# PLATTE SELF STORAGE

## GRADING AND EROSION CONTROL PLAN

### OVERVIEW SHEET

AUGUST 2024

OVERVIEW SHEET

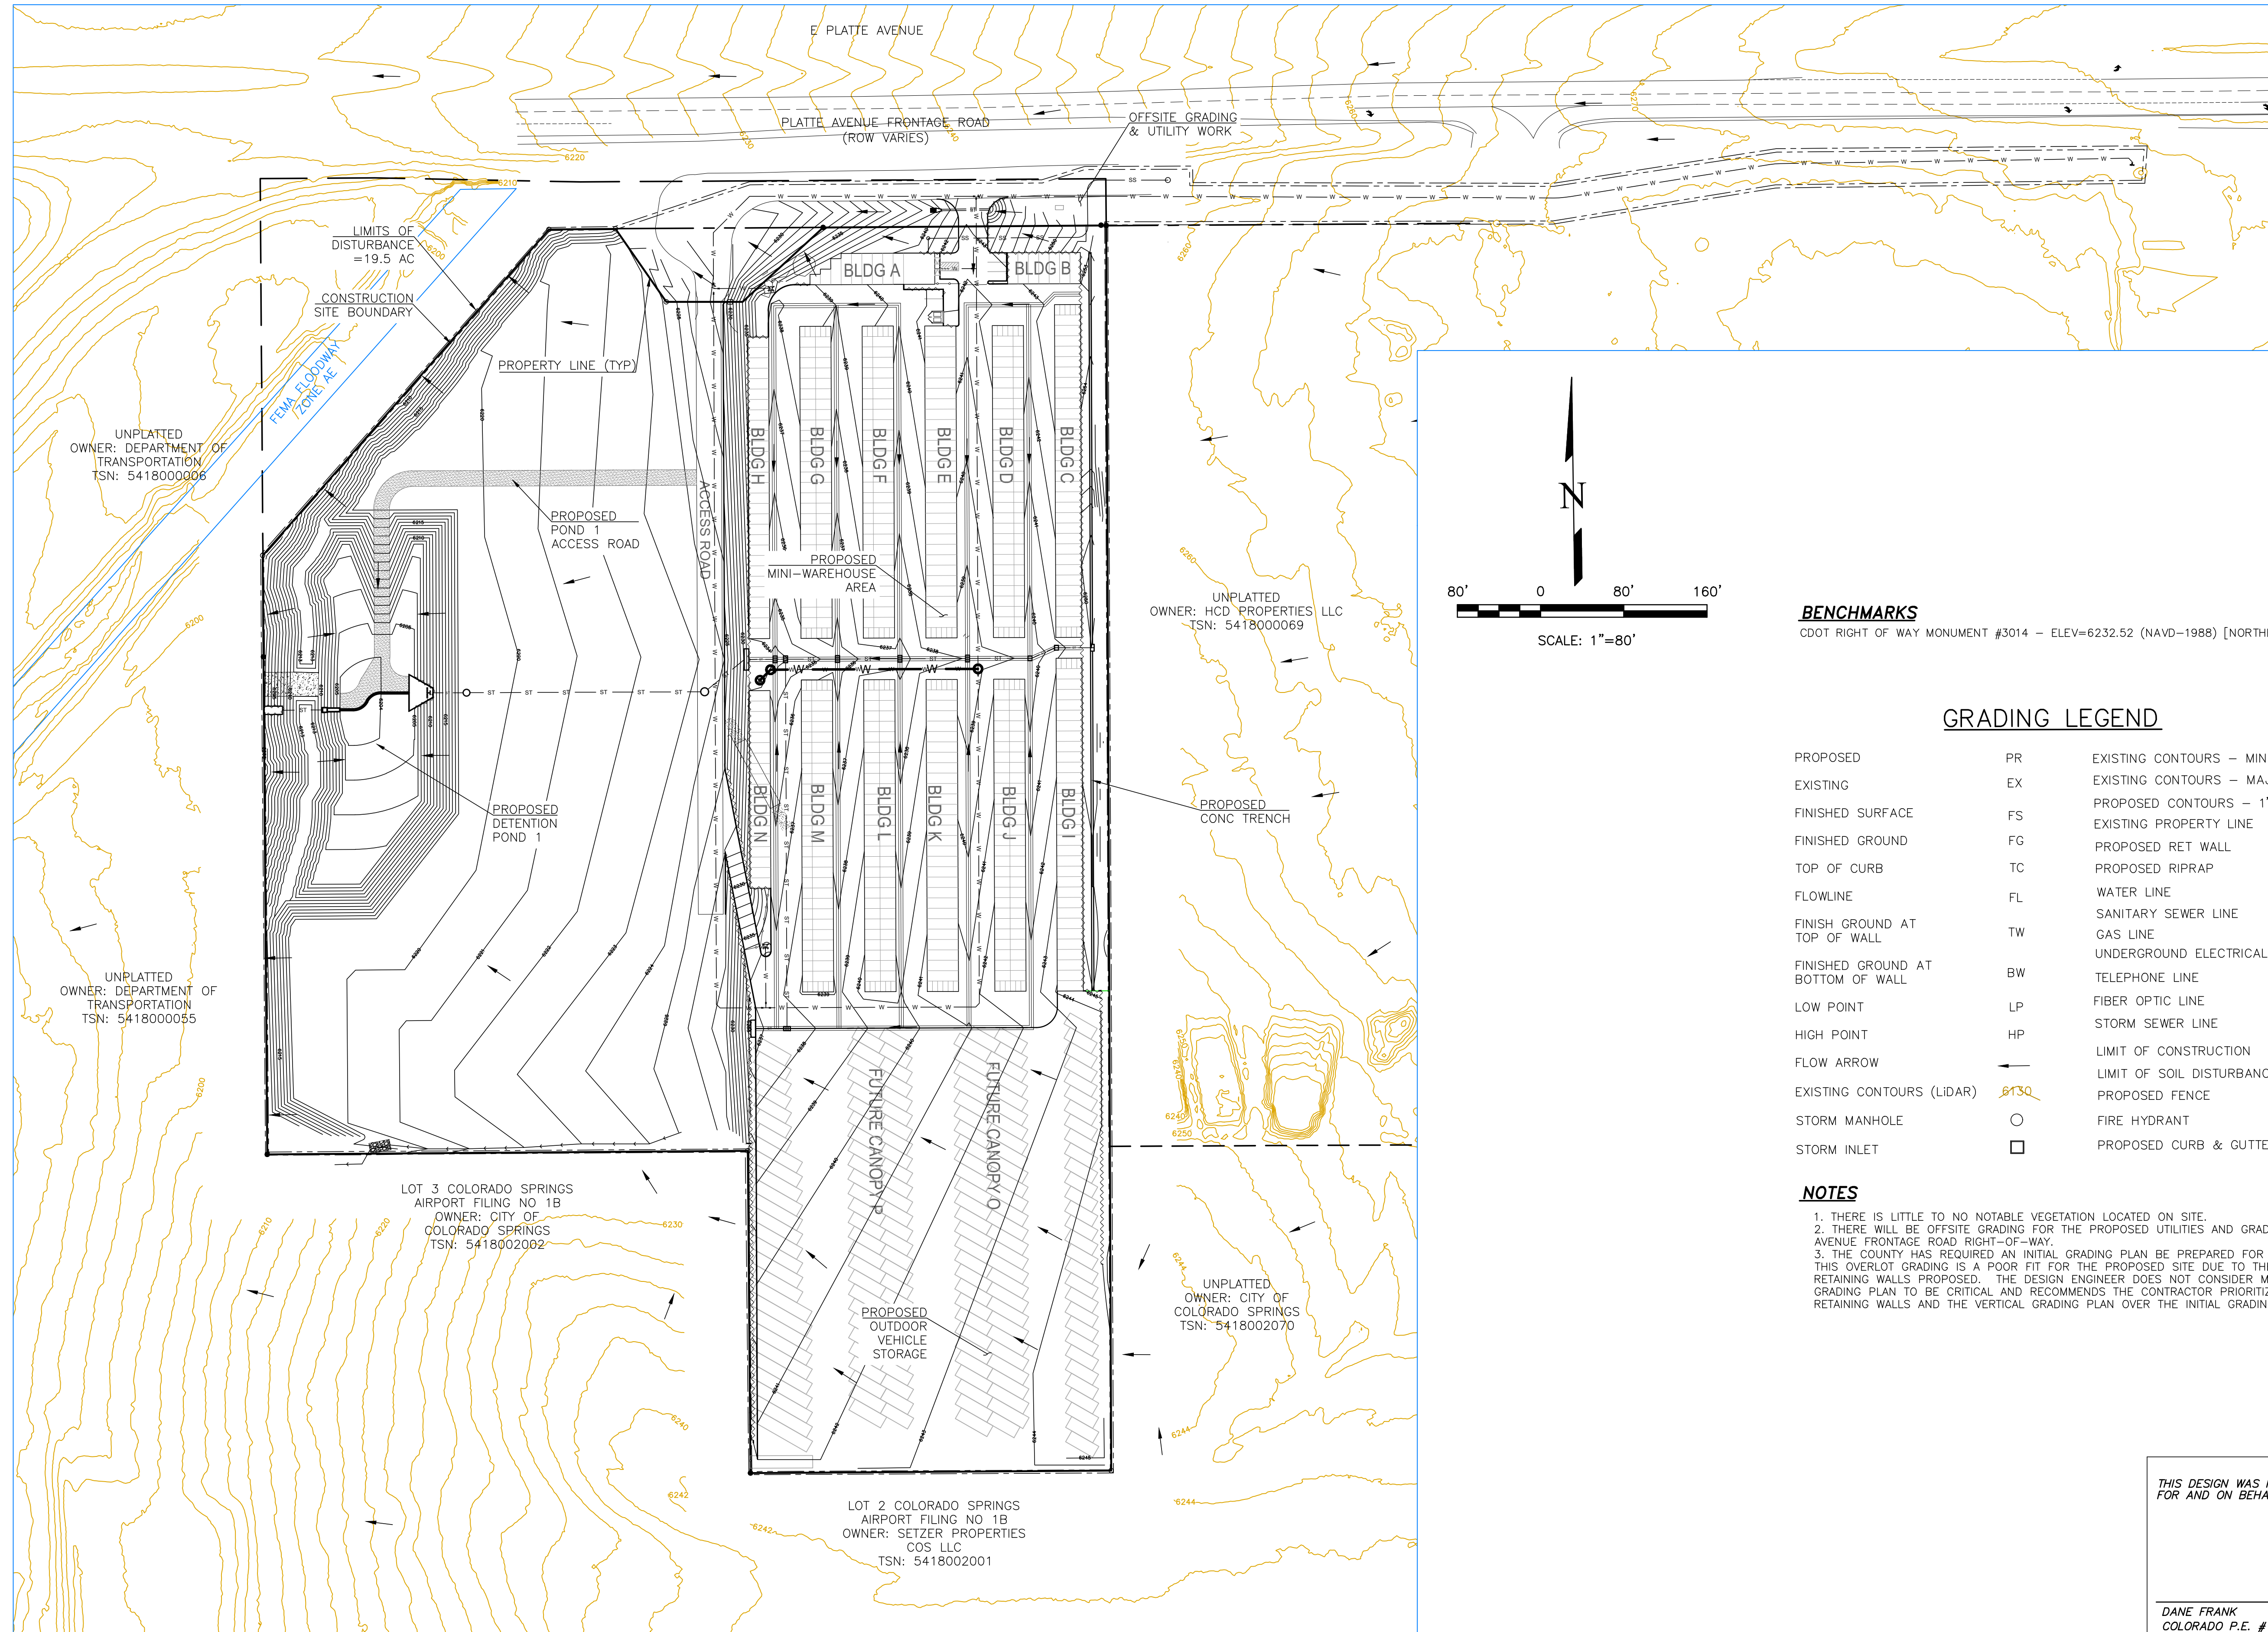
Unresolved from Submittal 1: The comment response stated that the applicant will need to grade the entire lot. Please update or remove this note. The County is not requiring overlot grading for the entire site, if the applicant wants to that is fine but this note reads as if the County is requiring overlot grading.

Overlot grading will not be required and if only a portion of the lot is proposed to be developed it is not recommended to disturb more soil than necessary. With the grading and erosion control plans you do need initial, interim, and final control measures shown but the initial does not need to be for the entire overlot area if the applicant/engineer does not prefer that. Please clarify this statement. Typical comment for all sheets with this note.

Note revised to remove mention of overlot grading, but this note is here so avoid questions from the contractor about why we have an initial grading plan when we do not feel it should not be prioritized.

STORM SEWER MAIN RUN - PLAN & PROFILE
 HORZ SCALE: 1"=40' - VERT SCALE: 1"=4'

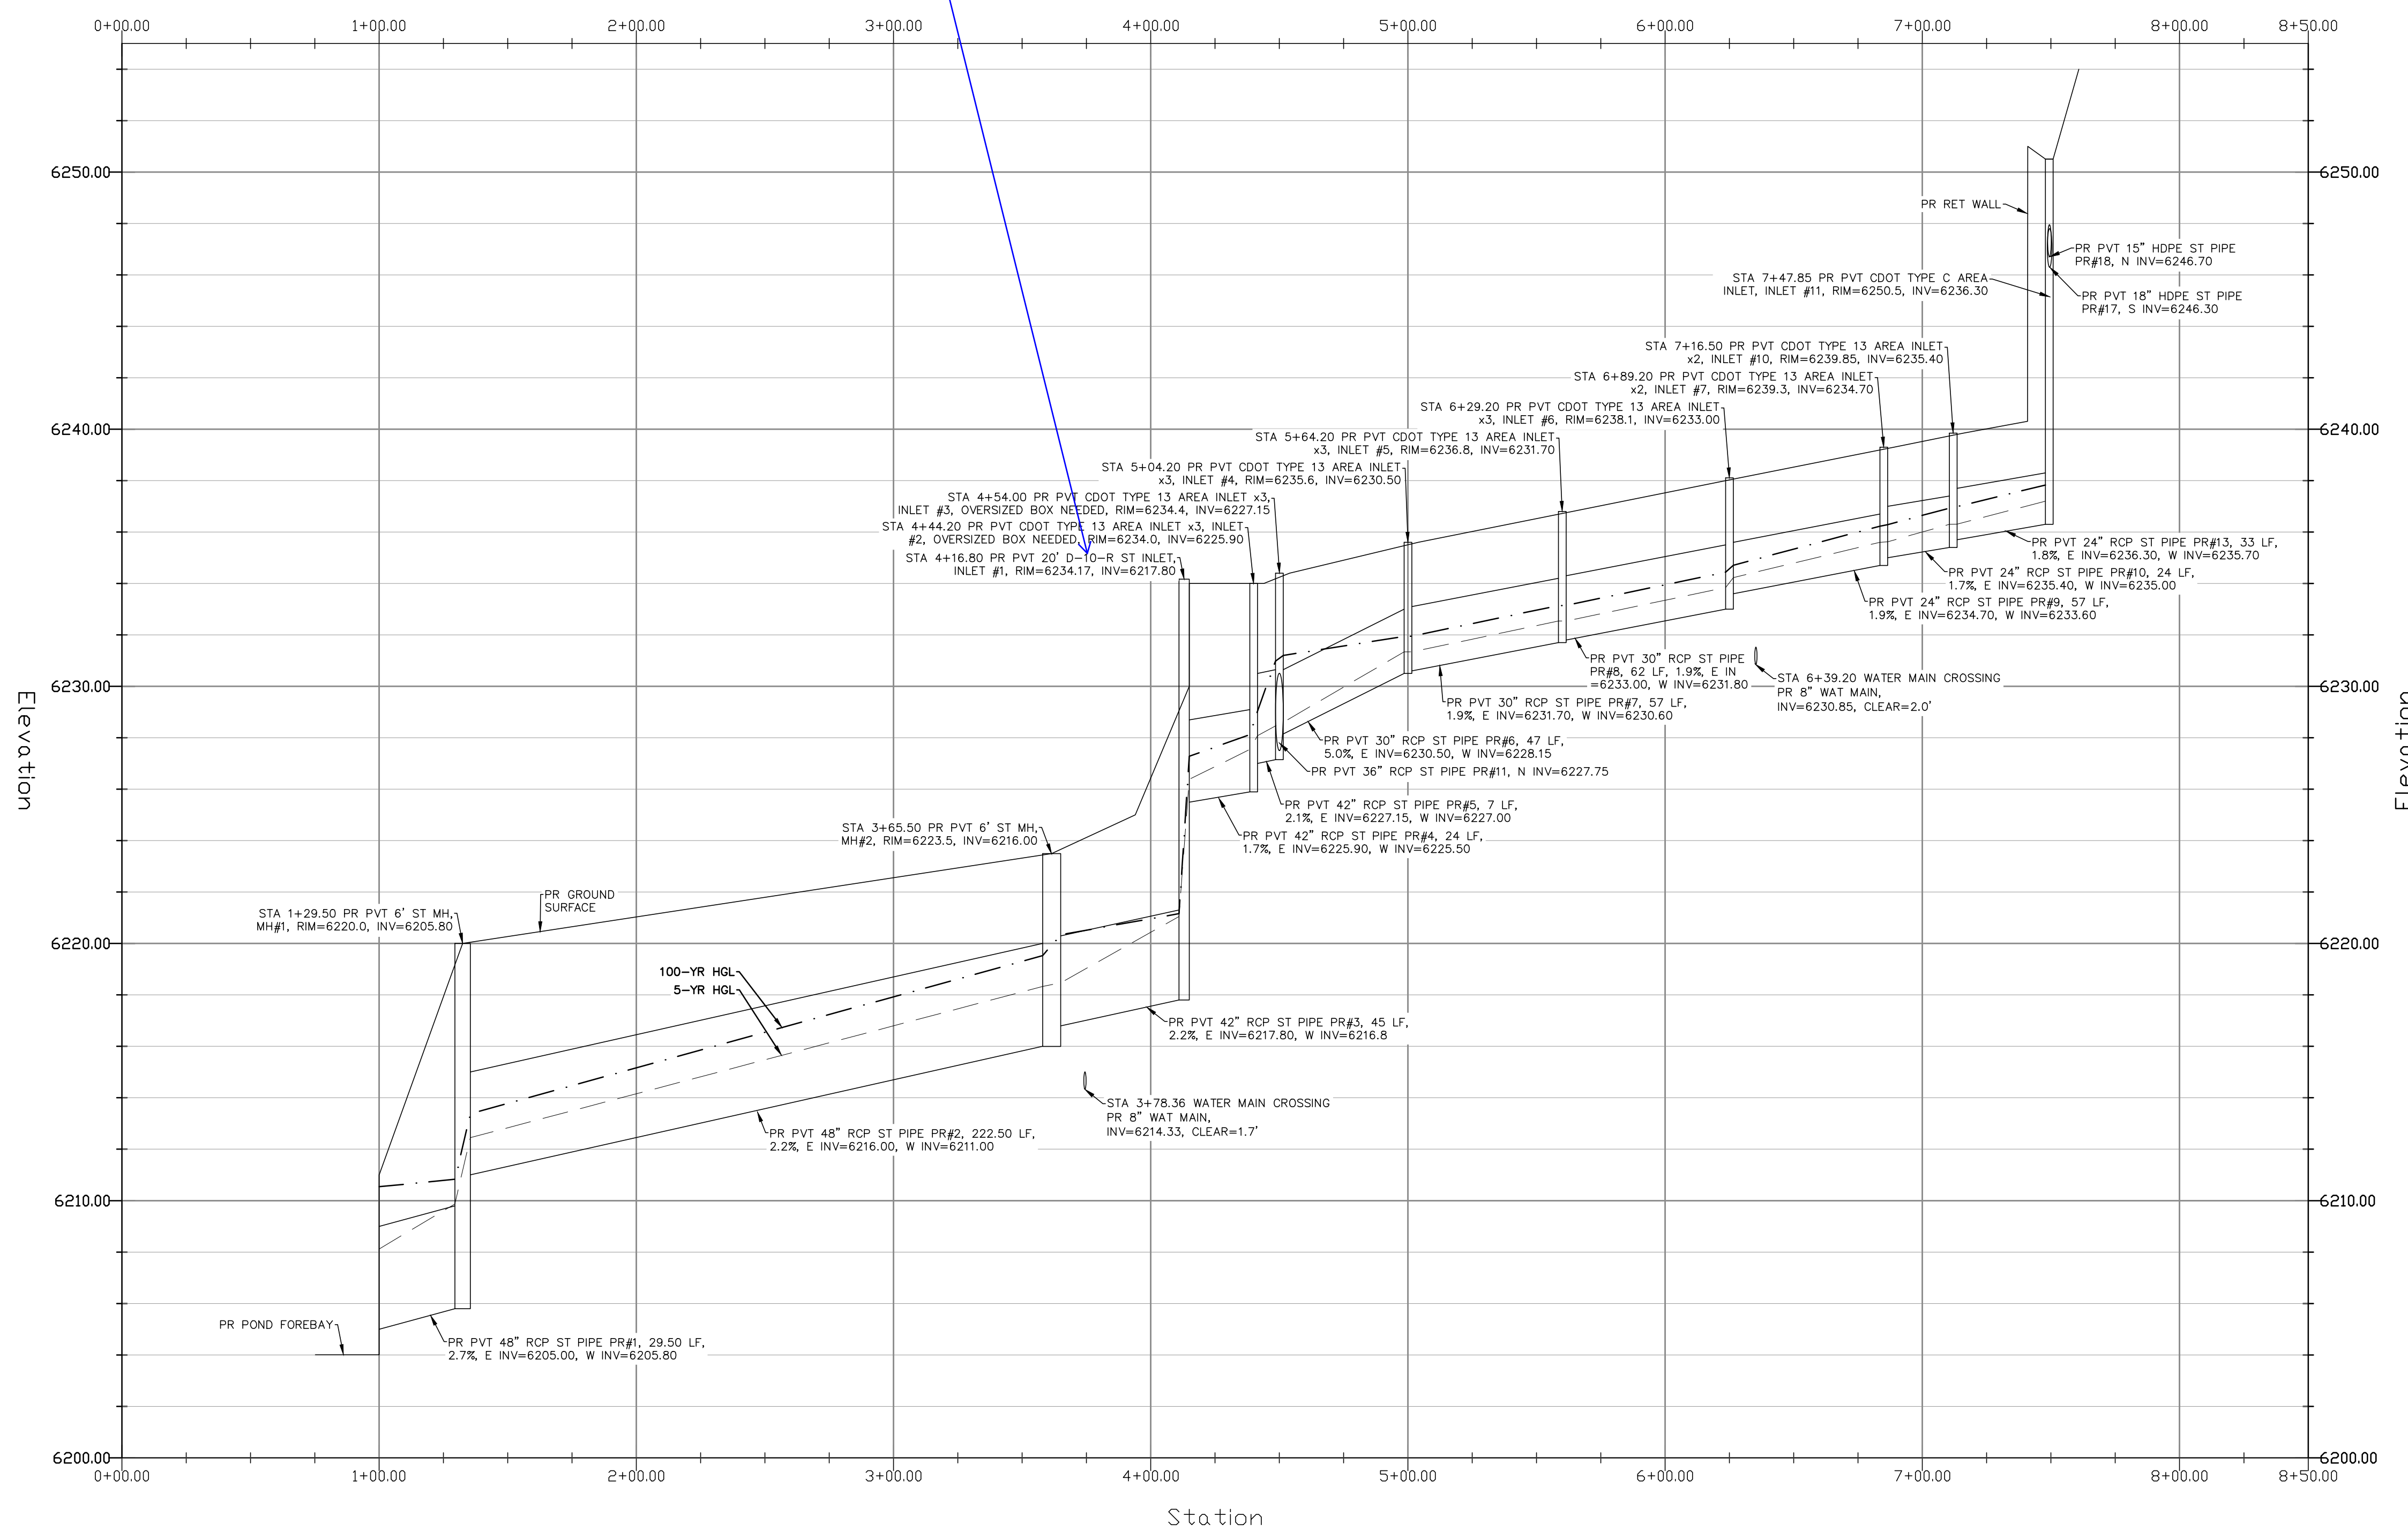
**Unresolved:**  
 Per ECM Section 3.3.1.J.2, inside top slopes of conduits of different sizes should be continuous in elevation. Revise pipes for tops to be continuous or provide deviation.

**I CHANGED IT. FYI - THIS IS A WORSE HYDRAULIC DESIGN. THE HGLS RAISED IN TWO PIPE SECTIONS AND THE HYDRAULIC JUMP IS LARGER.**
